DELEGATED HOUSEHOLDER DECISION

Item No. Report of the Head of Planning and Enforcement**Address** 14 MILL ROAD WEST DRAYTON**Development:** Installation of vehicular crossover to front**LBH Ref Nos:** **68283/APP/2017/4440****Drawing Nos:** 01
Location Plan (1:1250)**Date Plans Received:** 08/12/2017**Date(s) of Amendment(s):****Date Application Valid:** 08/12/2017**1. CONSIDERATIONS****1.1 Site and Locality**

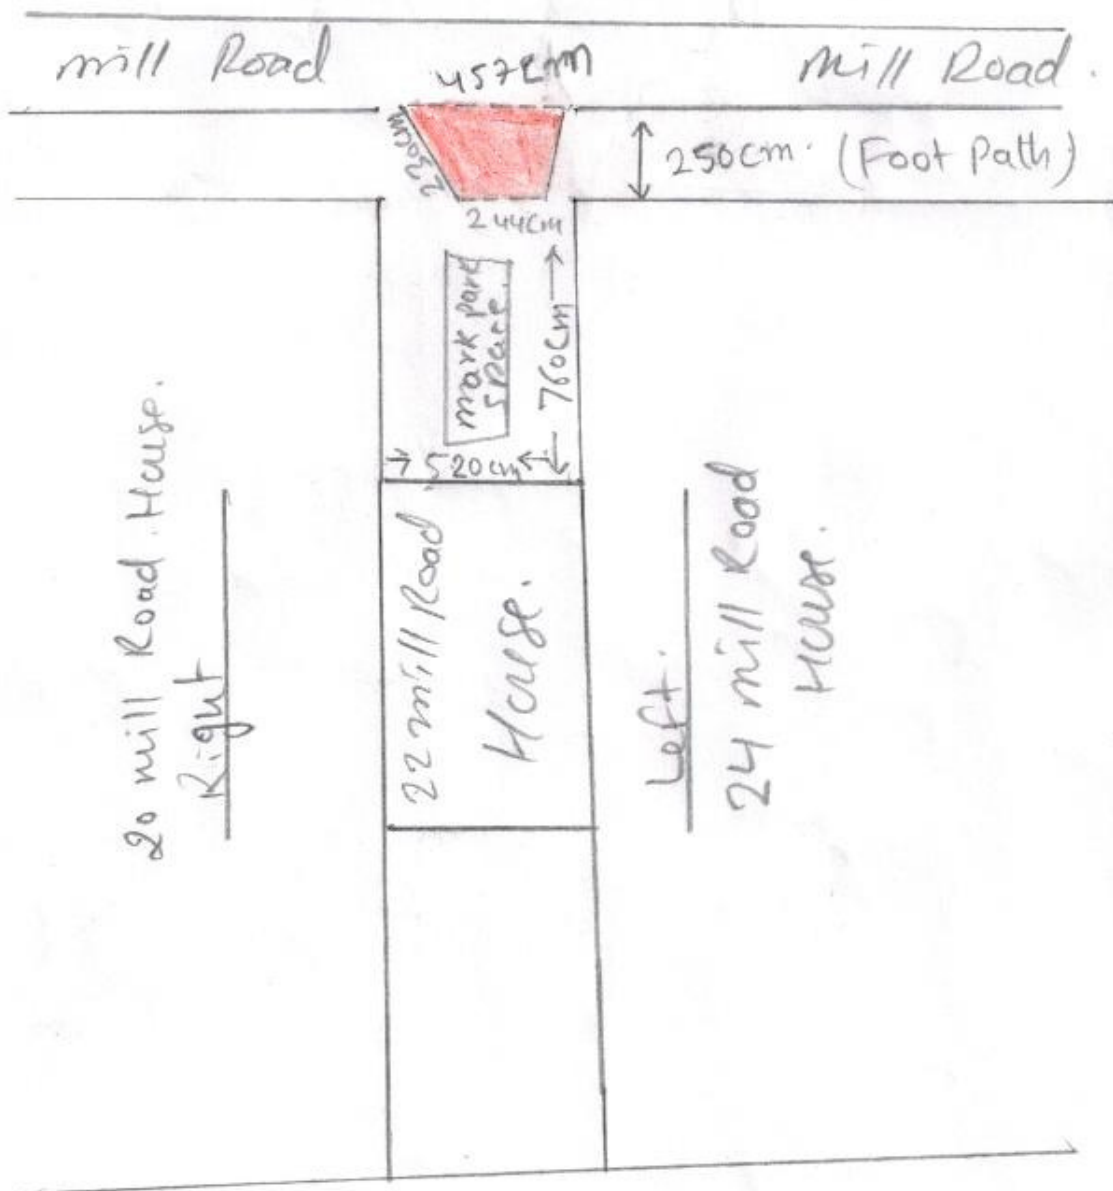
This application is for the installation of a crossover at Mill Road West Drayton. Mill Road is a classified road on the Council road network. There are no waiting restrictions in place outside the property. The applicant has a concrete hardstanding at the front of the property and an opportunity for rear access from the garage block at the rear. There was a previous application for a hardstand and crossover in 2012 and that was refused. The Council is not in favour of vehicular crossovers on Classified roads where a vehicle cannot enter and leave the property in a forward gear and that would be the case in this instance. On the basis of the above comments I suggest you refuse the application on road safety grounds as vehicles either entering or leaving the property would have to reverse into a busy stream of traffic on a classified road.

The Council produces Standing advice with regard to acceptable dimensions for crossovers. For domestic crossovers this is 2.4 metres at the back of the public footway which increases to 4.6 metres at the kerbline. The proposed crossover would comply with this advice, only 0.1 m wider to the back of the public footway.

Mill Road is a busy road with a steady stream of traffic even during off-peak hours. The proposal does not and cannot provide for any on-site turning and so additional reversing movements either on or off the road would be required. This would interrupt flow along the highway and further manoeuvring on this part of the main road system would increase accident risk through direct conflict or distraction from the main task in hand for drivers on the principal route. Policy AM7 of the Hillingdon Local Plan: Part Two - Saved UDP Policies (November 2012) aims, amongst other matters, to ensure that development would not prejudice the free flow of traffic or impact upon conditions related to highway safety. The proposed scheme would run contrary to these objectives which are also embodied within the Council's Supplementary Planning Document HDAS: Residential Extensions (HDAS).

The proposal, by reason of additional vehicles reversing on to Mill Road and the increase in the number of potential conflict points along the highway, would result in the disruption of the free flow of traffic and would be detrimental to highway and pedestrian safety, contrary to Policy AM7 of the Hillingdon Local Plan: Part Two - Saved UDP Policies (November 2012) and the adopted Supplementary Planning Document HDAS: Residential Extensions.
